Westmead Catholic Community Education Campus (SSD-10383)
Response to Submissions

ATTACHMENT 1 – KEY ISSUES

OPEN SPACE - LEVEL 04 & LEVEL 05
sheet

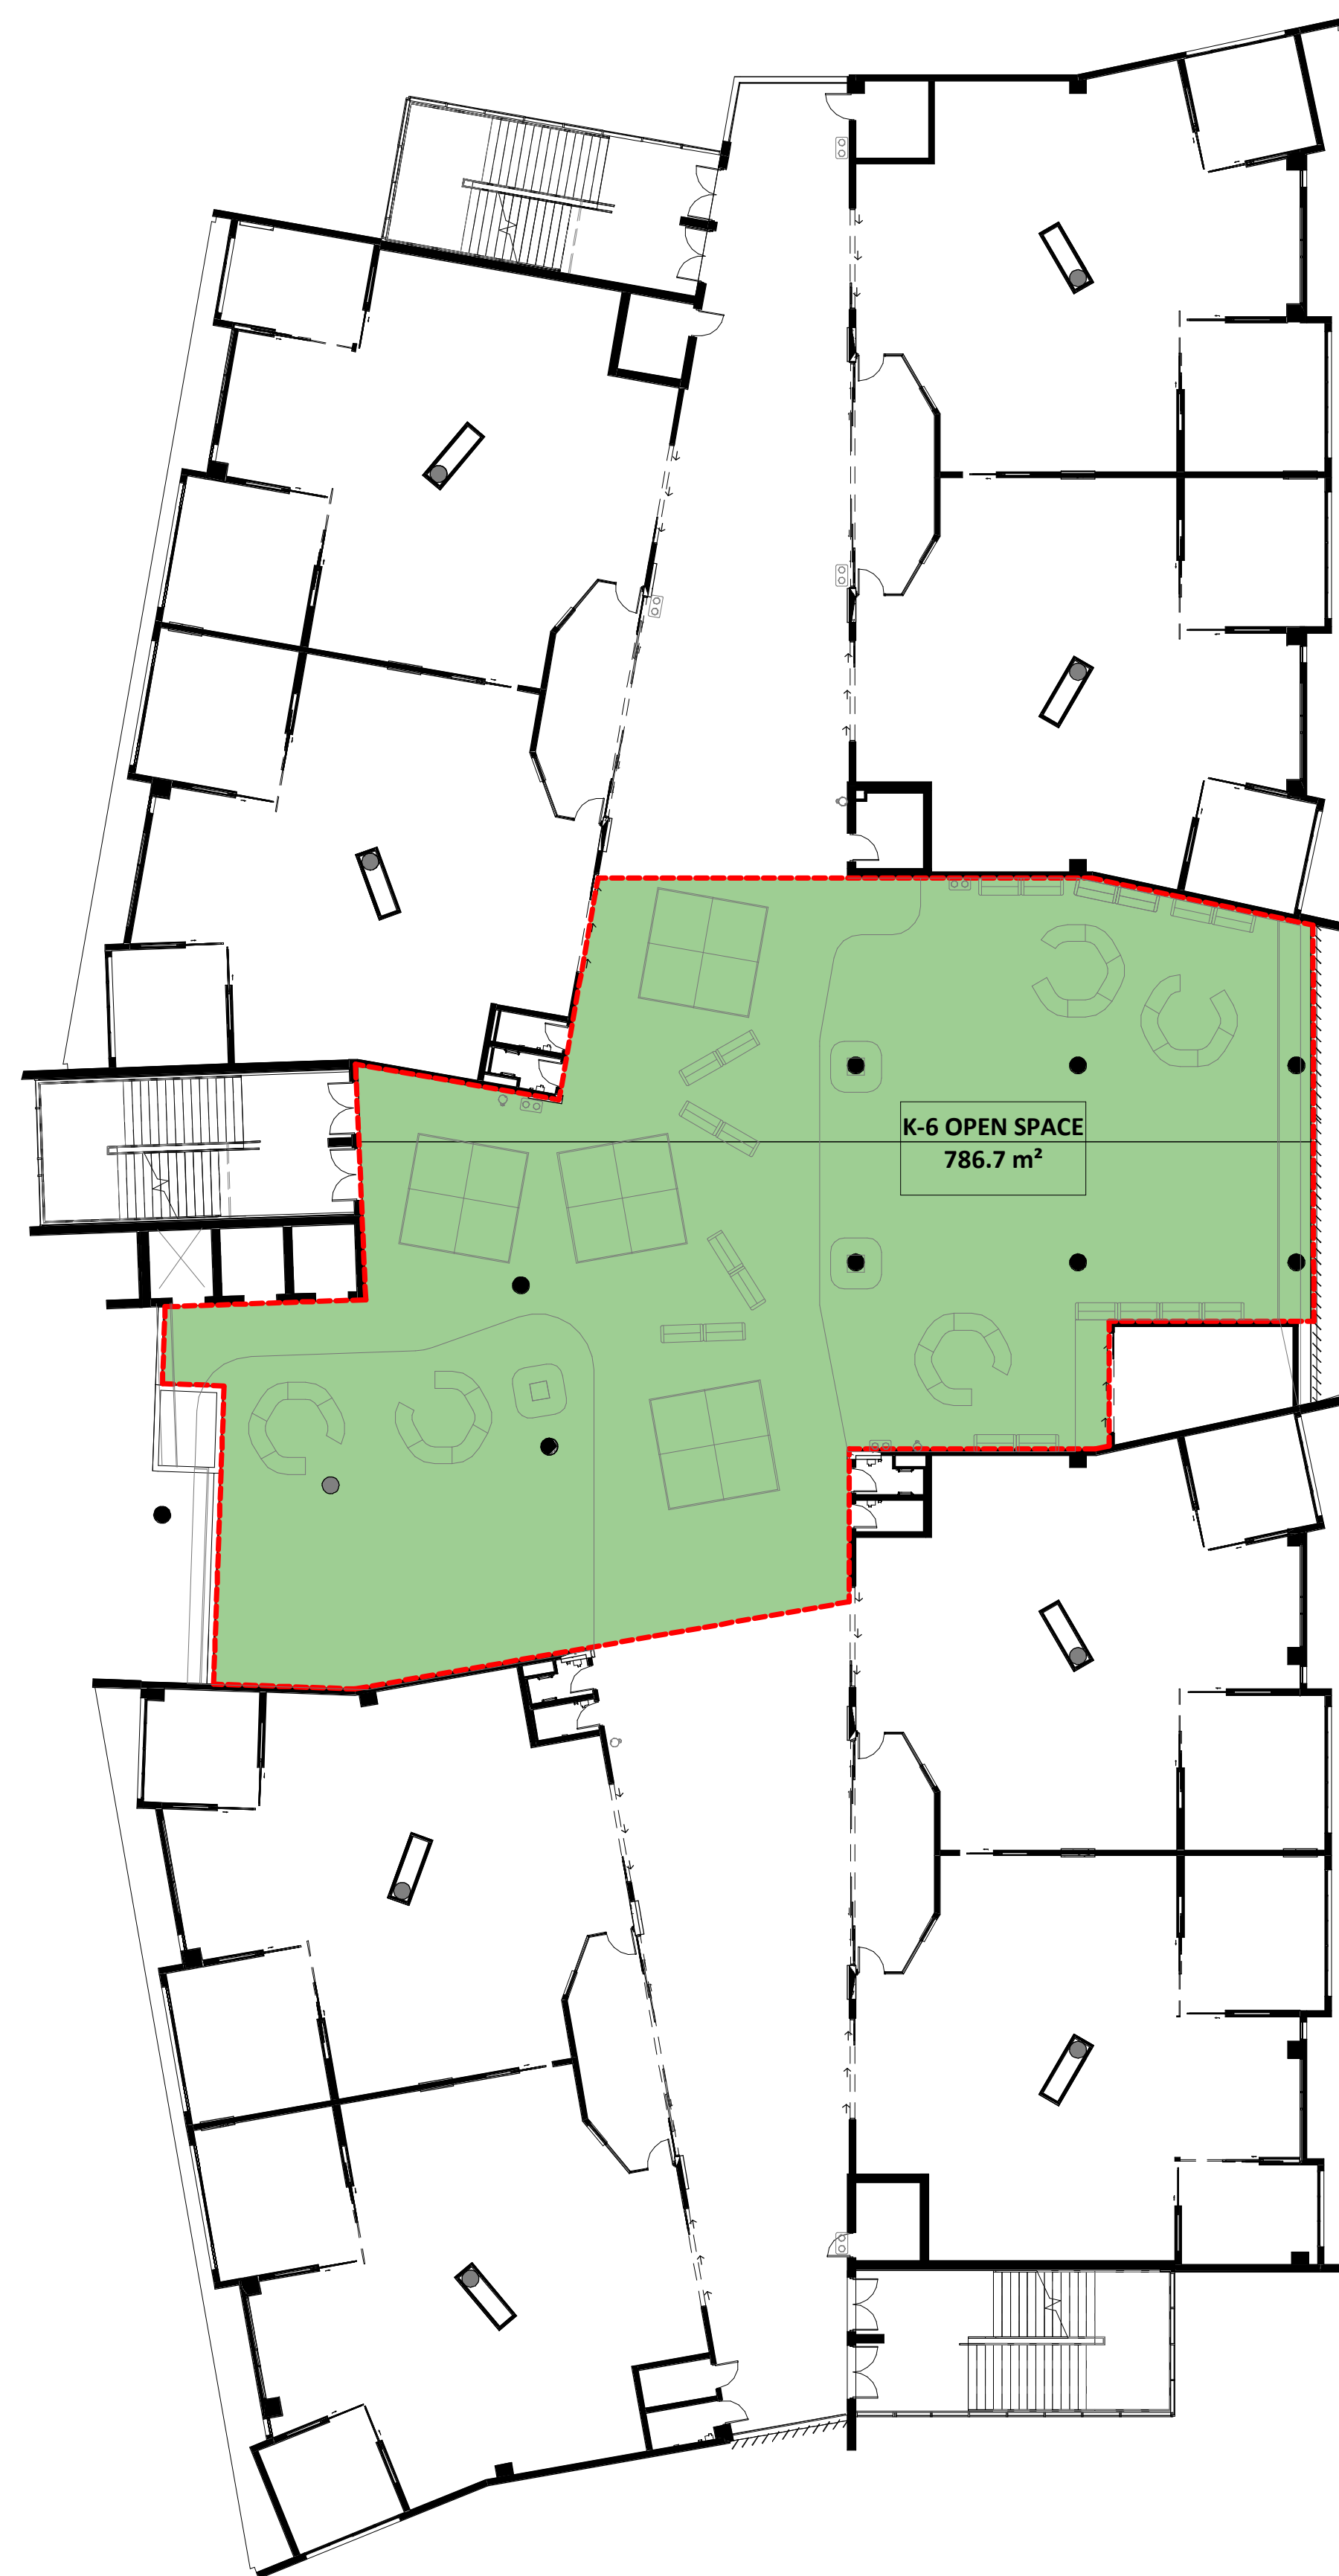
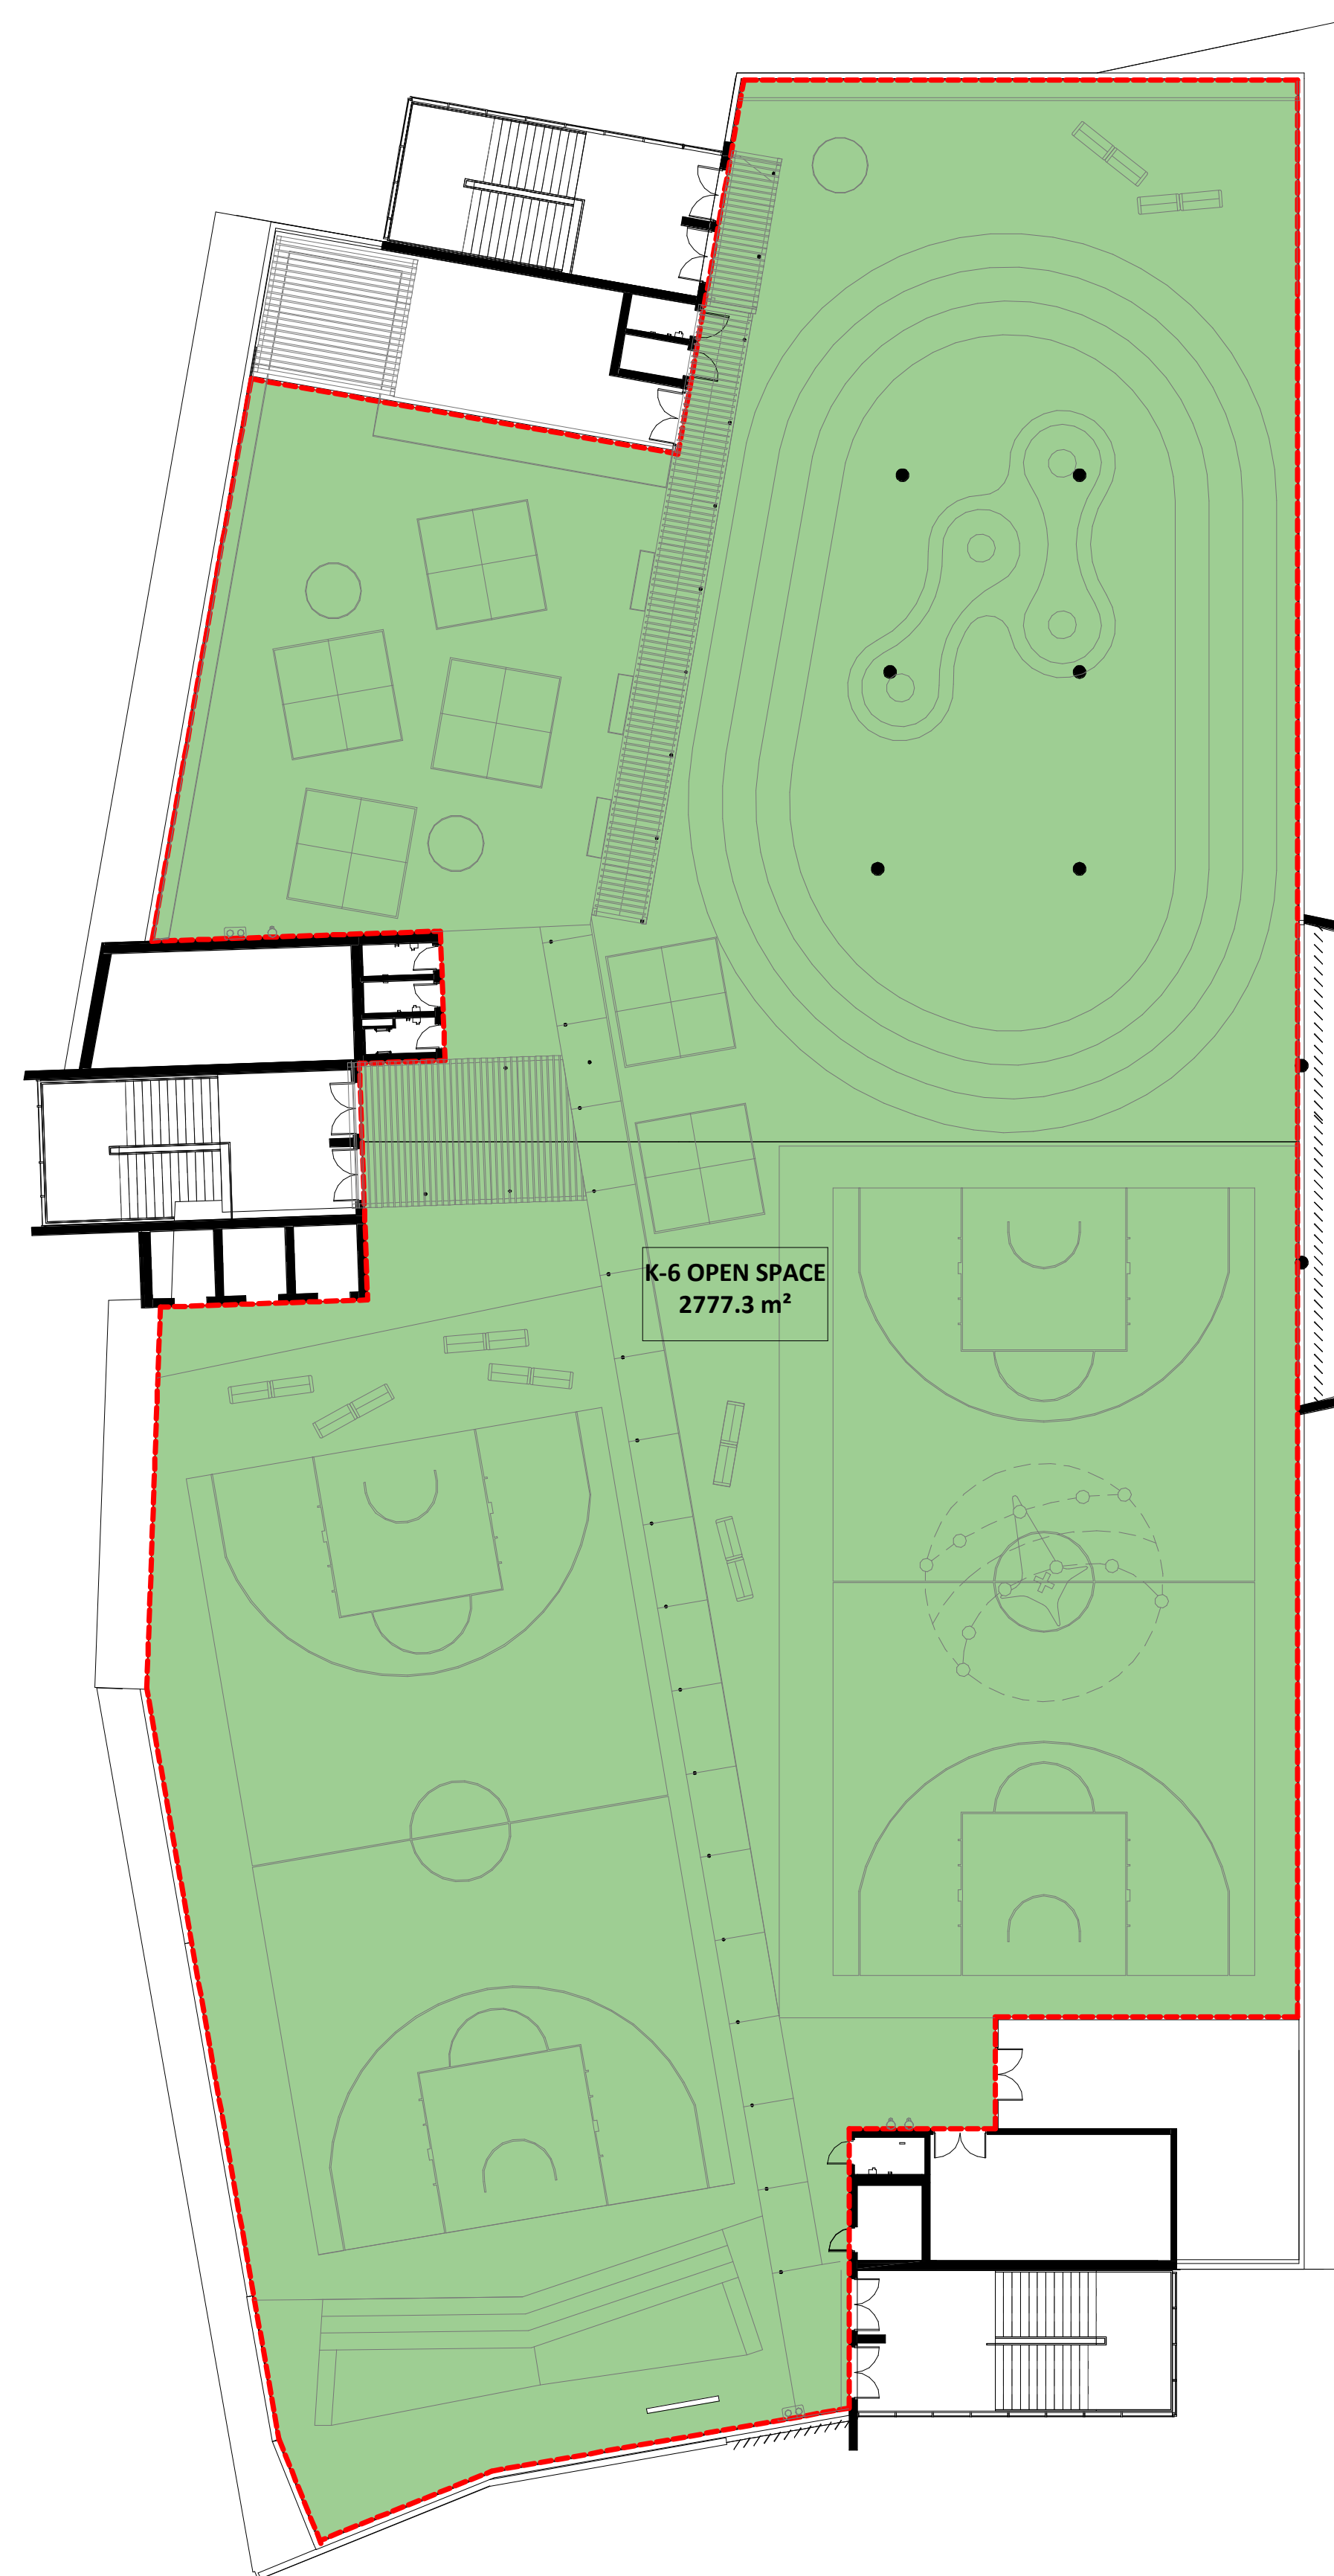
- the open space diagrams indicate that circulation areas in between classrooms have been added as open spaces. The circulation areas should be deleted from the calculation of open space areas.
